RE: Timber Clad structure at Harefield Hospital - Ref: 9011/APP/2018/1854

Retention of hospital waste store (Retrospective Application) with new boundary hedge planting.

P Ground Floor Plan as Proposed
PL-003 SCALE: 1:50 @ A1

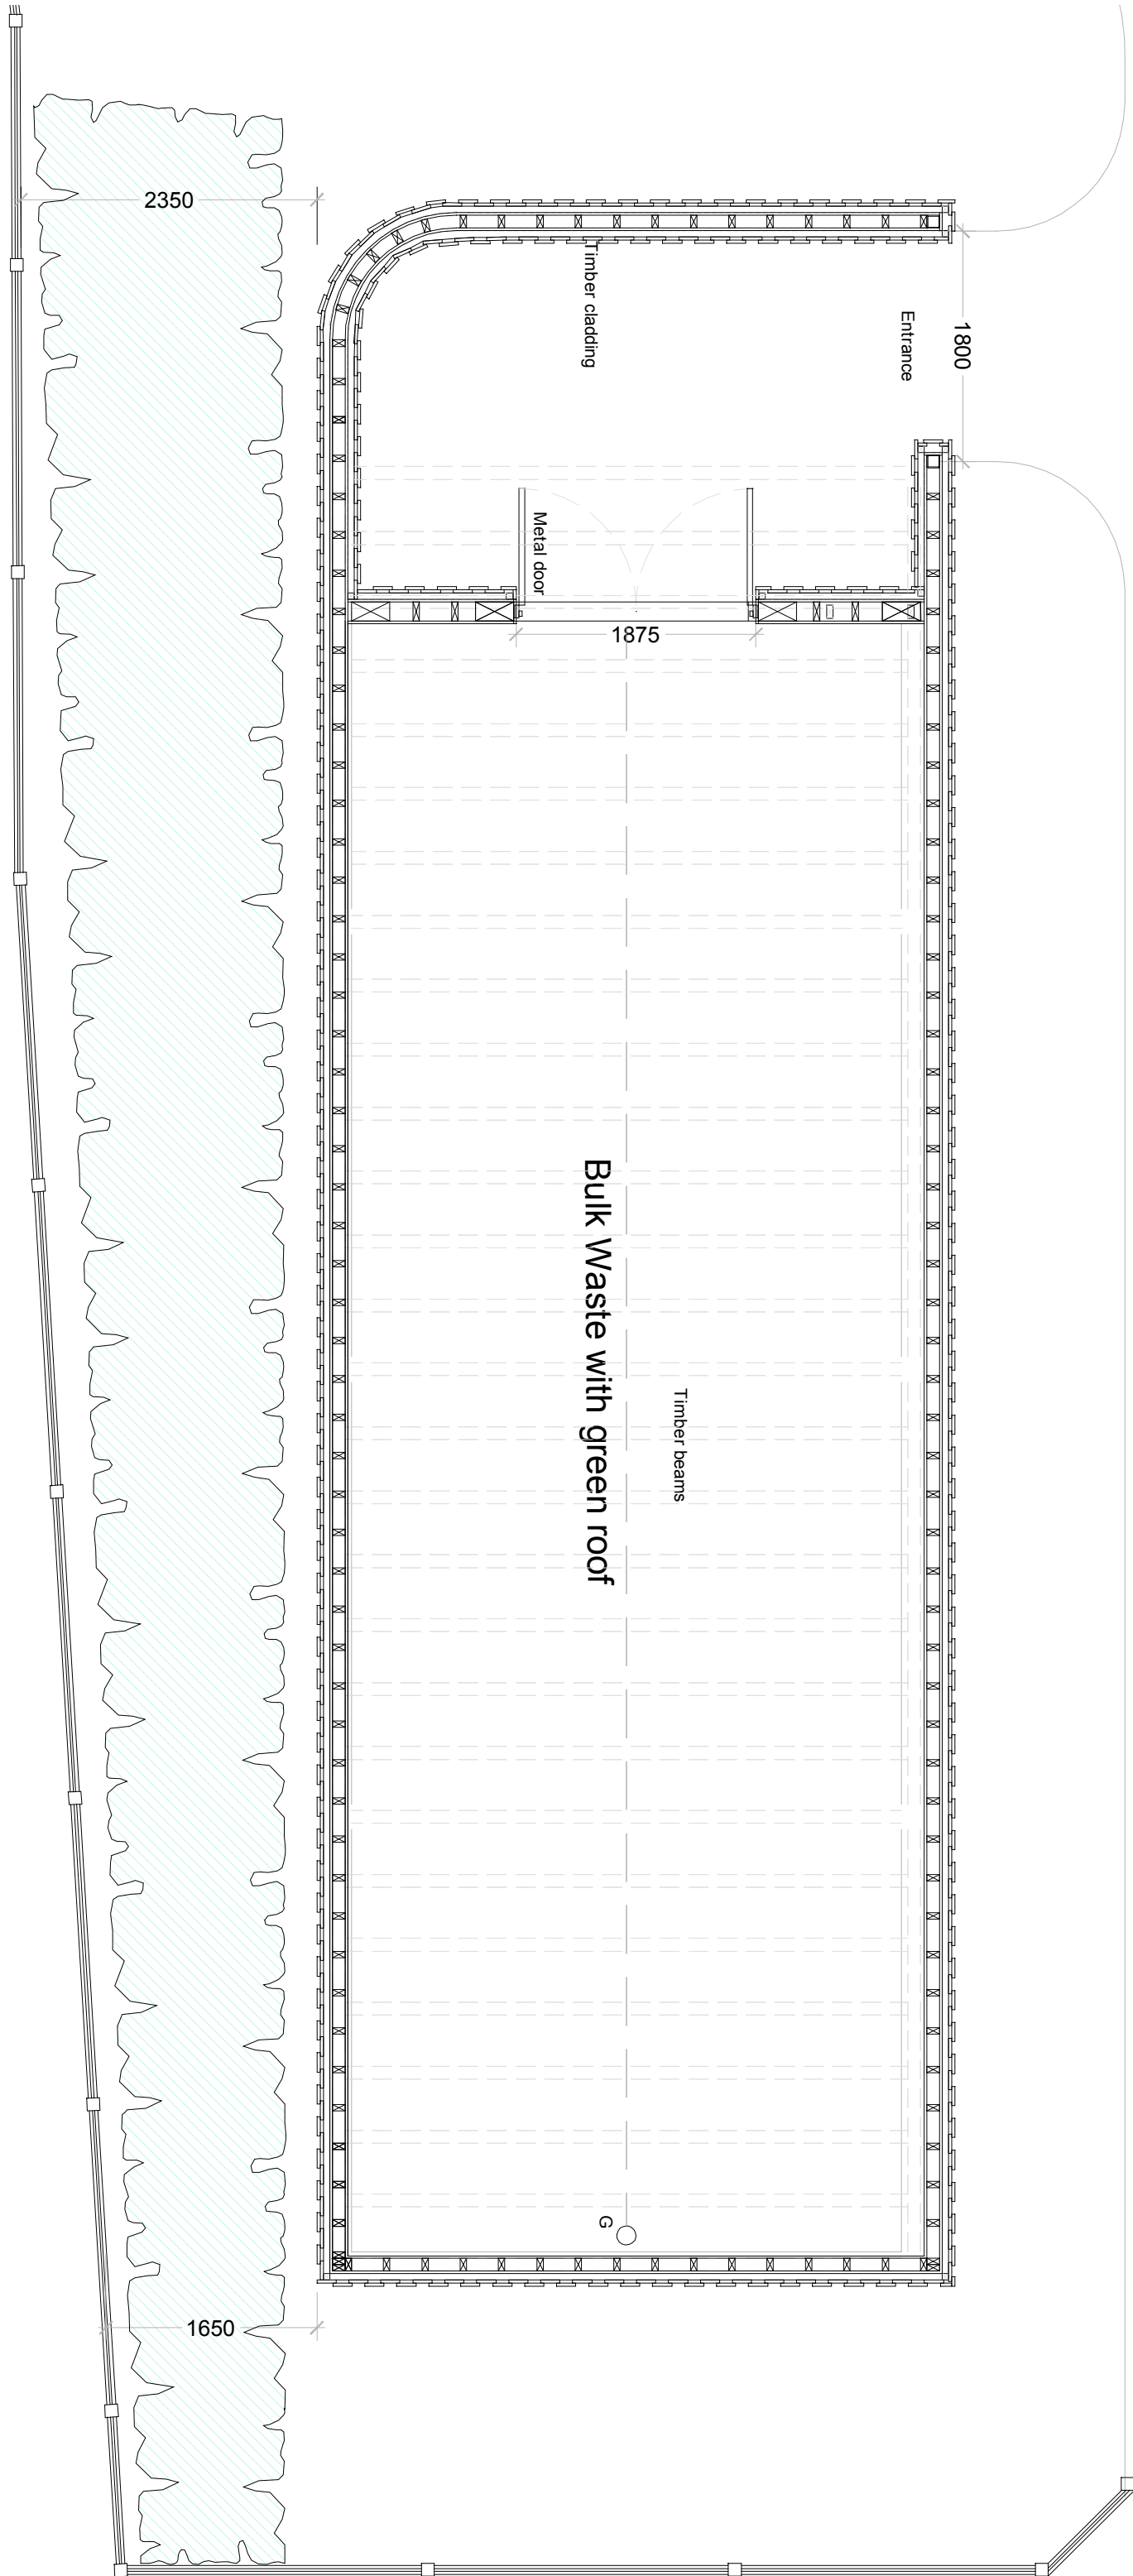
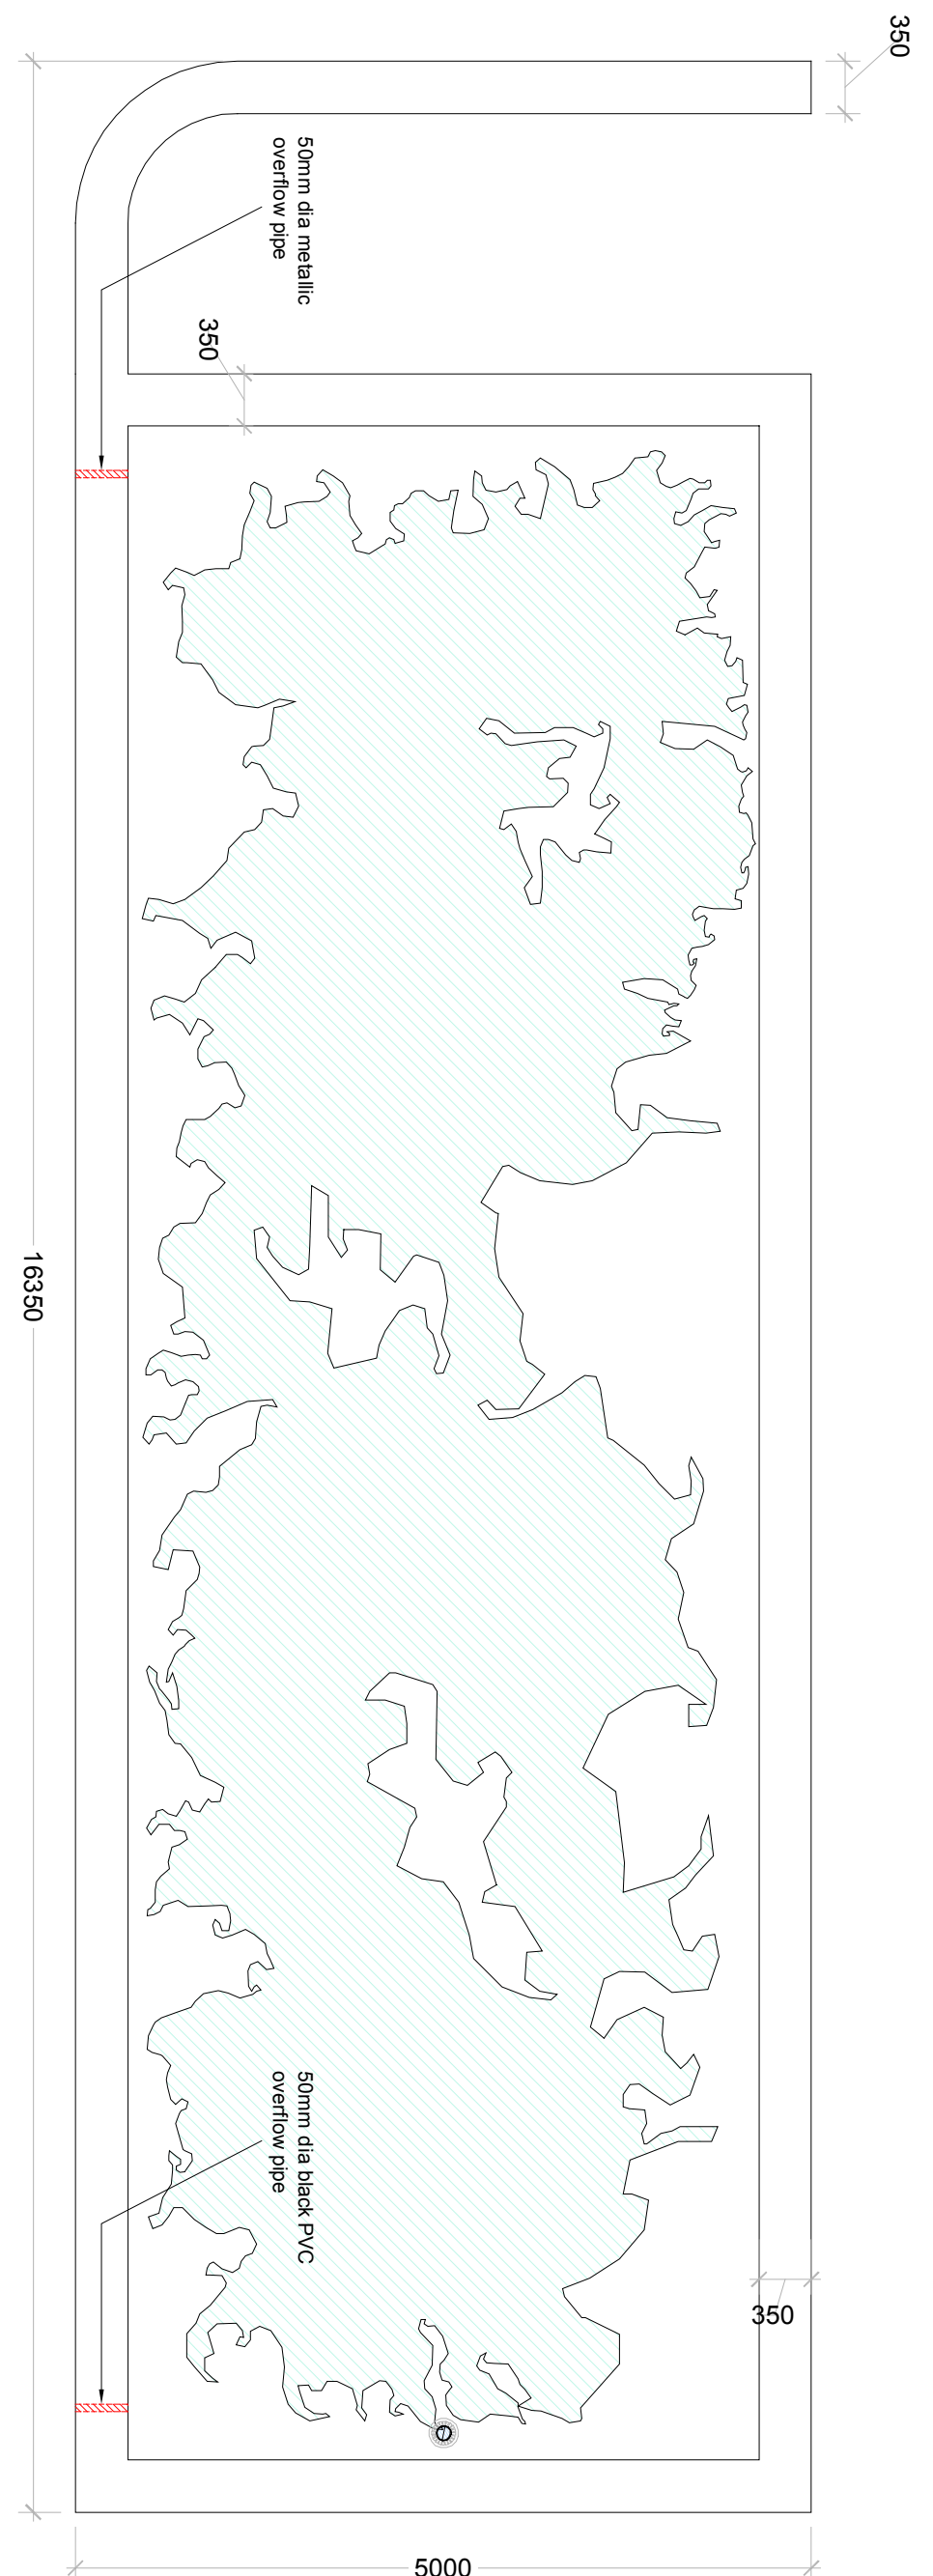
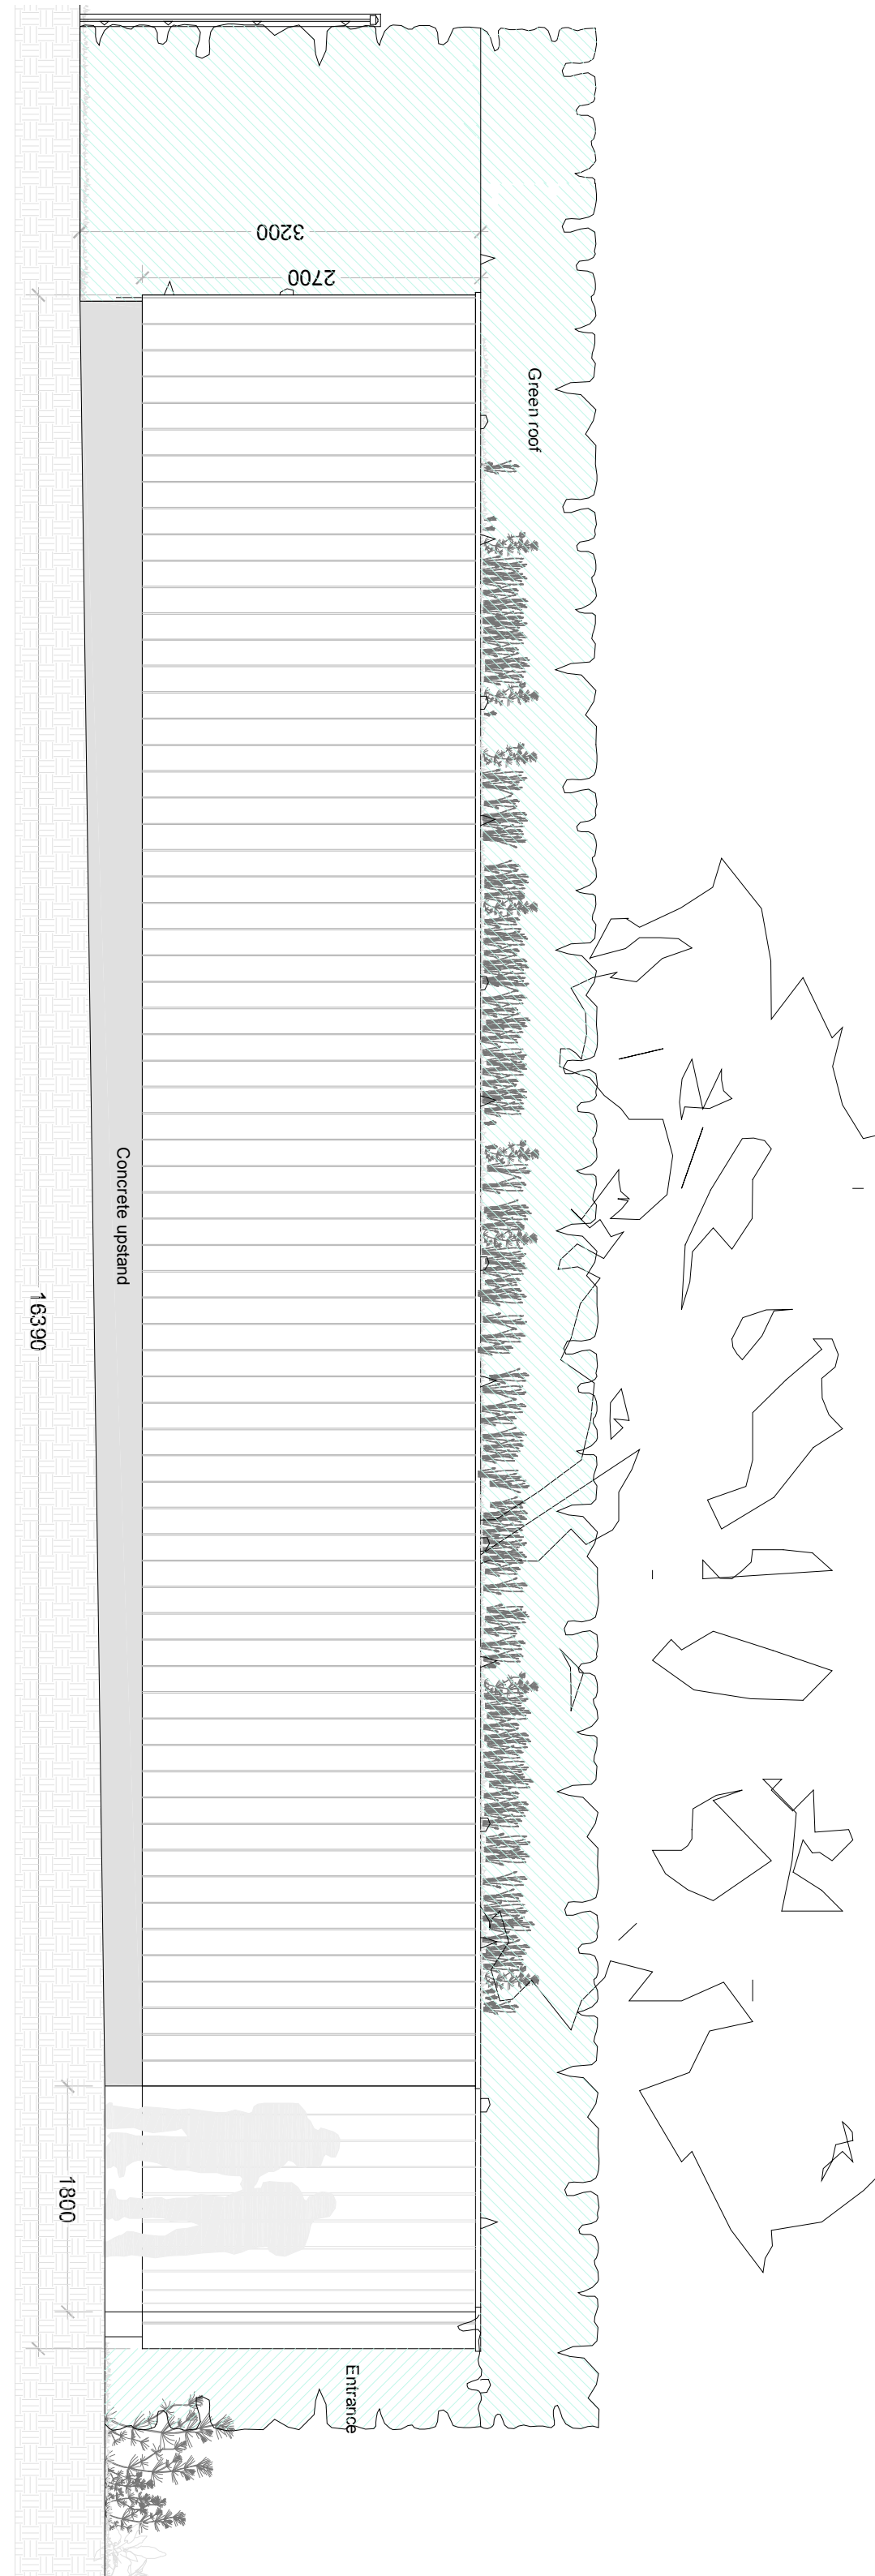
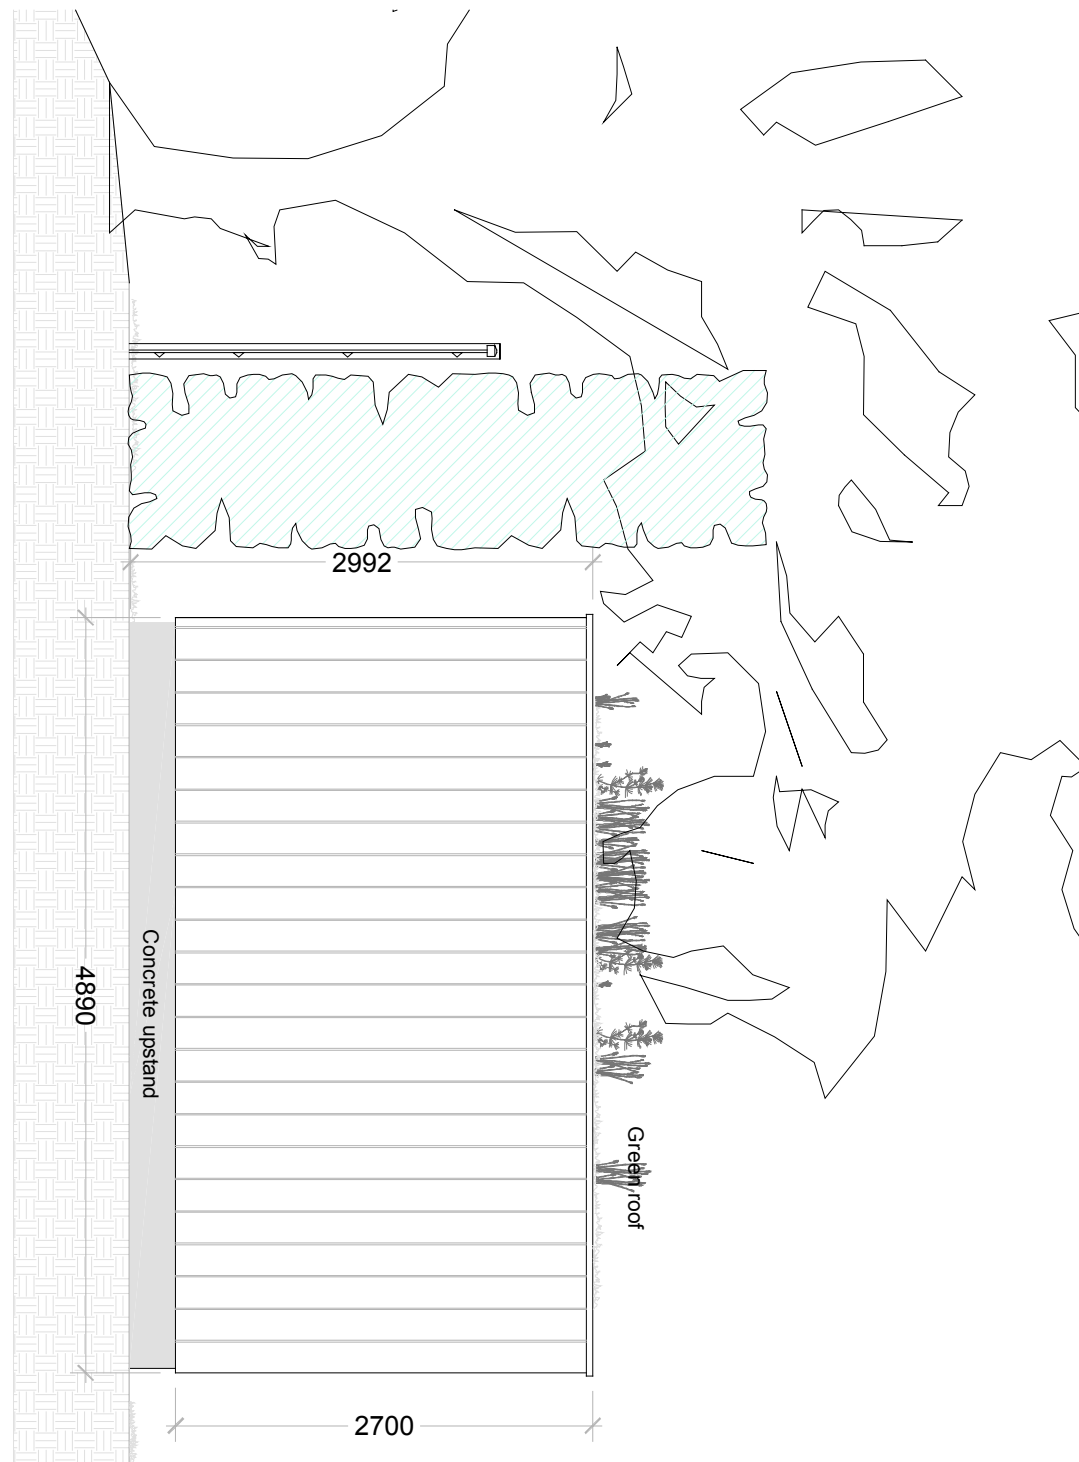
There is a side fence shown at the square end of the store on the floor/elevation plan which is not shown on the site plan, (described as 'Location Plan' - Drw. No. PL-002 refers) - can this be added - it will make things a little clearer.

With respect to the dimensions of the structure, it is considered that the bin store as erected on site exceeds the dimensions of the bin store submitted to the Council under 9011/APP/2015/3508. To this end, the West Elevation height measurement on approved plan stated 2.850m. This was measured at approx 3.2m this morning. There was other minor variations on the height of the structure. The length of the structure on previously approved plans was shown at 14.660m. This was measured on site at approx. 16.35m. The width of the structure as previously approved was 4.2m and this was measured on site at
